## 1.0 Introduction

- 1.1 This Technical Note responds to comments received from the Local Highway Authority dated 14<sup>th</sup> July.

## 2.0 Kidlington Roundabout Improvements

Proposed Site Access  
MAC drawing no. 122-TA05 E

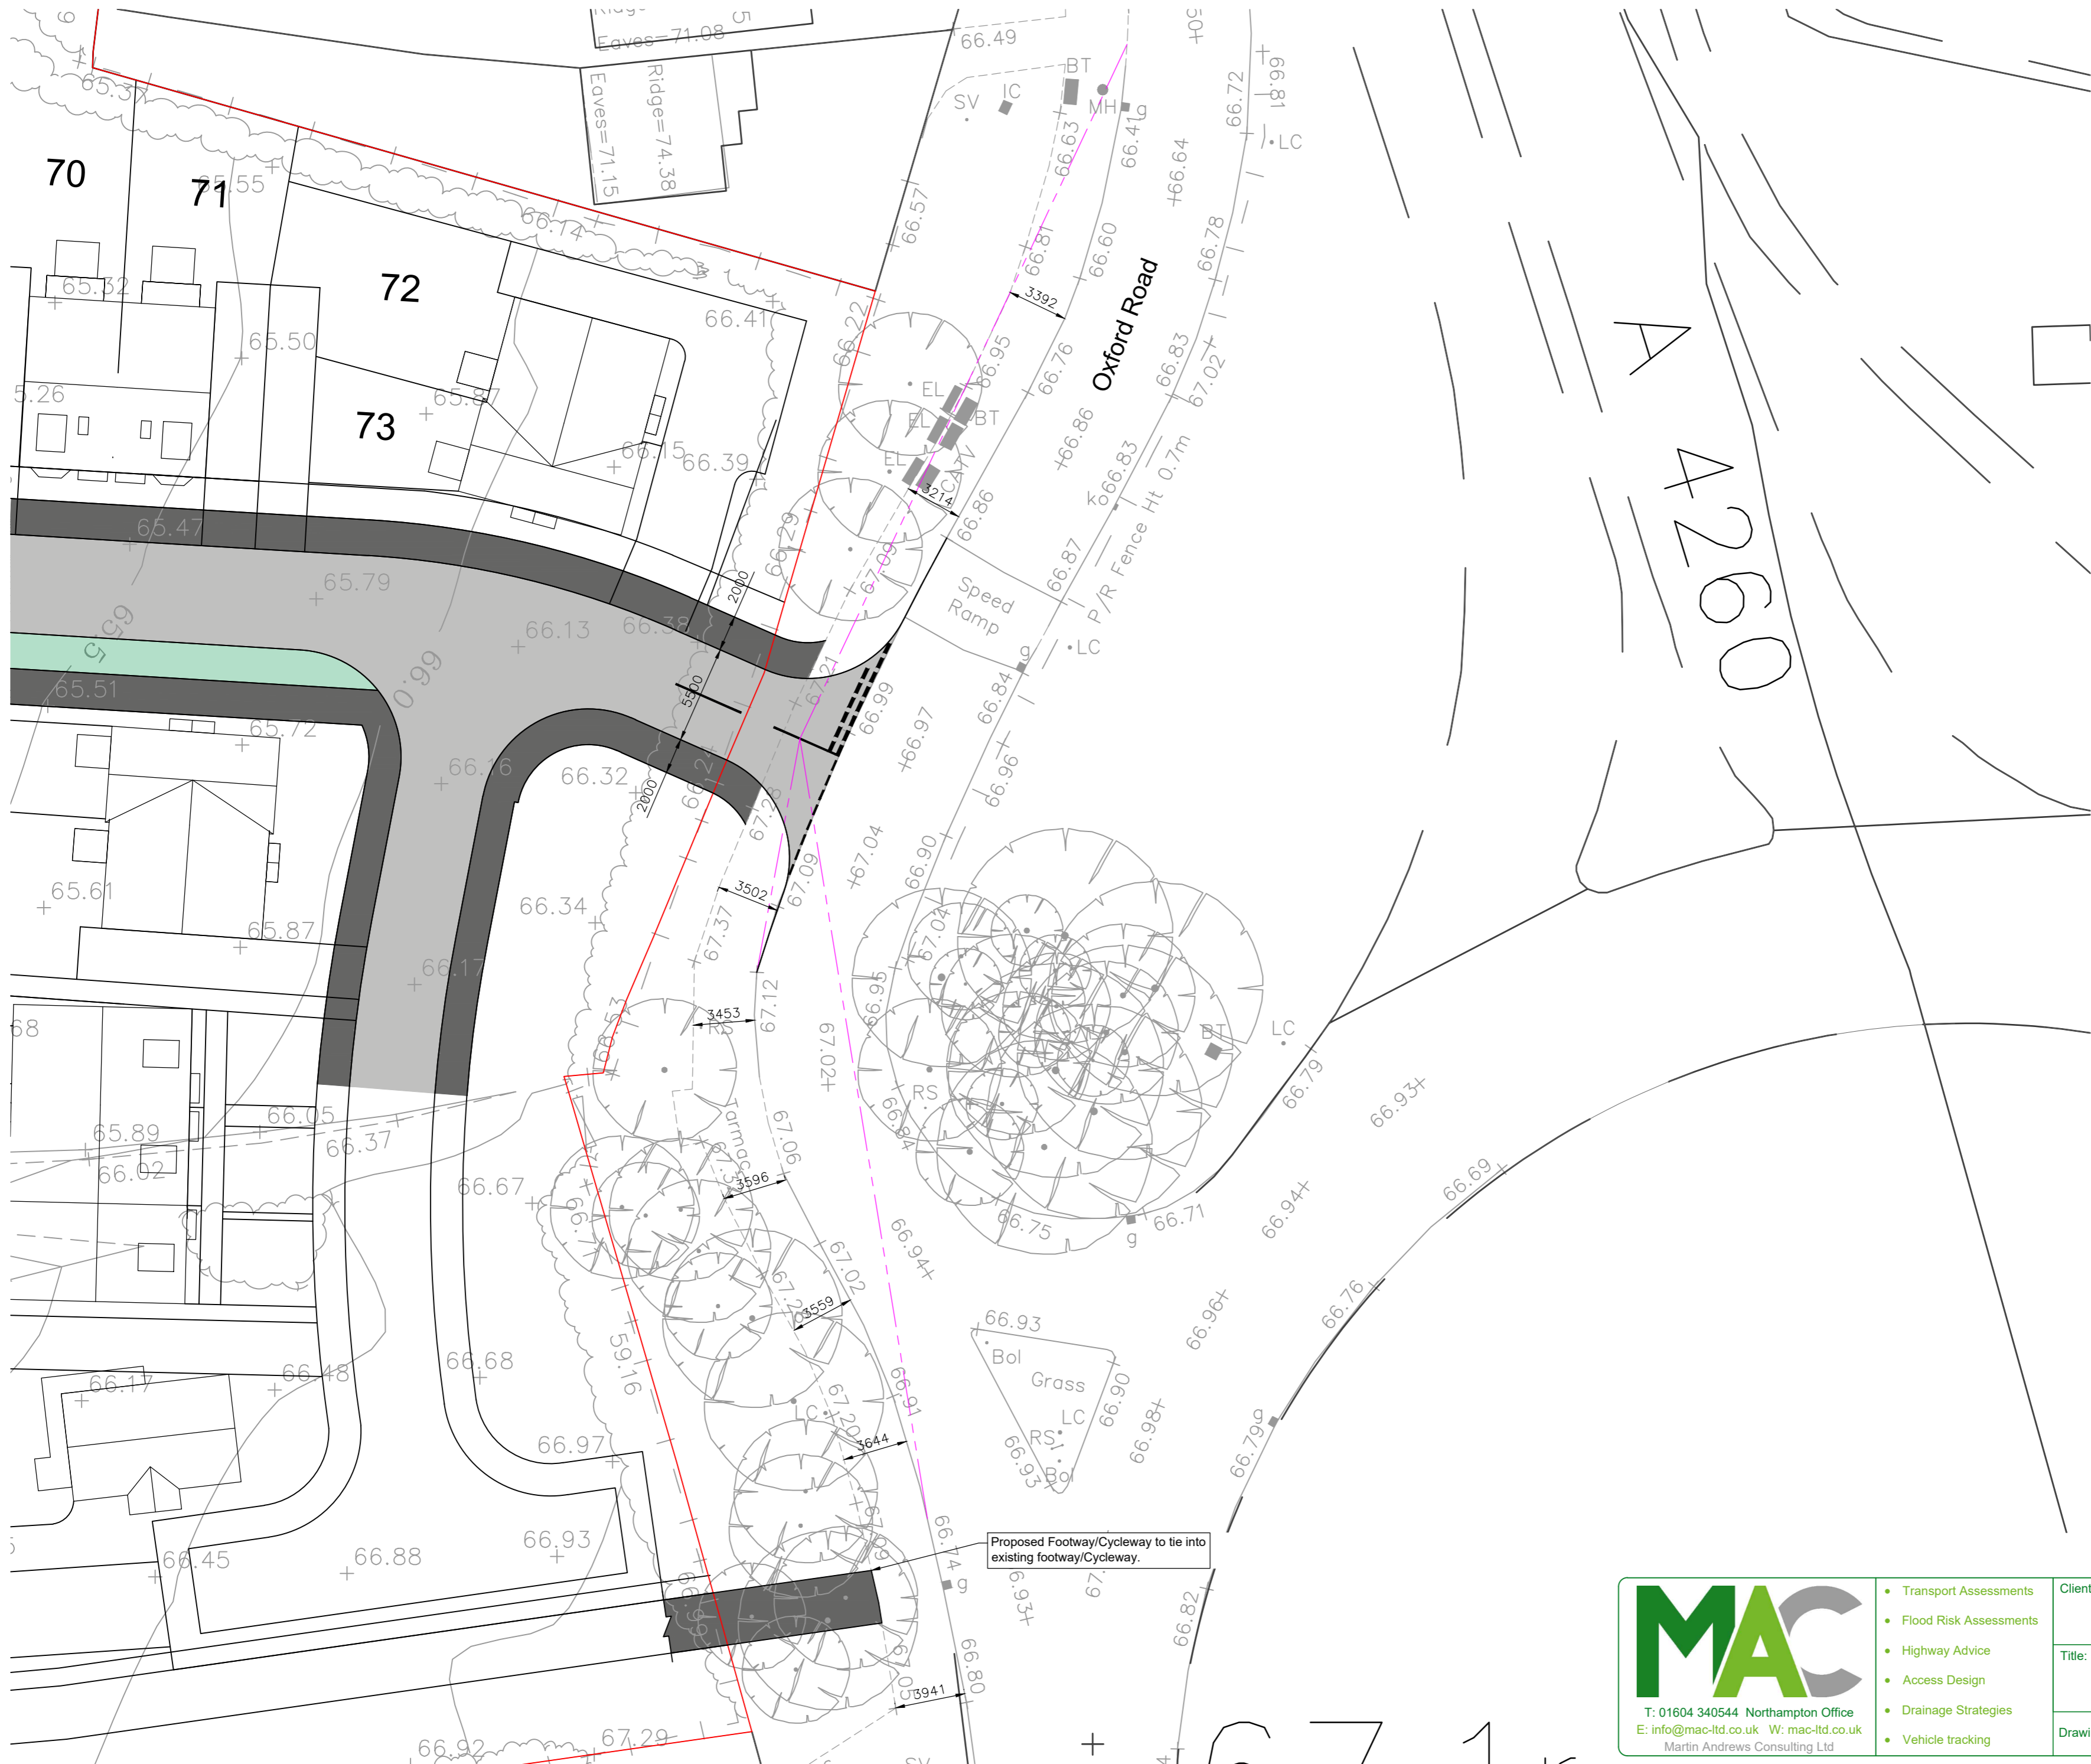
- 2.5 An updated version of the access drawing is enclosed in **Appendix A**. This shows that the footway and shared footway / cycleway to the south of the site is typically 3.5m wide. This existing provision connect with the proposals planned for Kidlington Roundabout as shown on the plan in **Appendix B**. The short element of footway between the site and existing shared footway / cycleway could be reclassified as a shared footway / cycleway to provide total connectivity between the proposed development and wider footway / cycleway provision.

- 3.1 As mentioned above there is existing 3+m wide infrastructure between site and the Kidlington Roundabout. Where this is not designated as a shared footway / cycleway between the development and the Kidlington Roundabout this could be altered as it already complies with the width requirements.

- 3.2 To the north of the access the proposed access connects with the existing footway which is in excess of 3m wide but reduces in width at the dwellings.
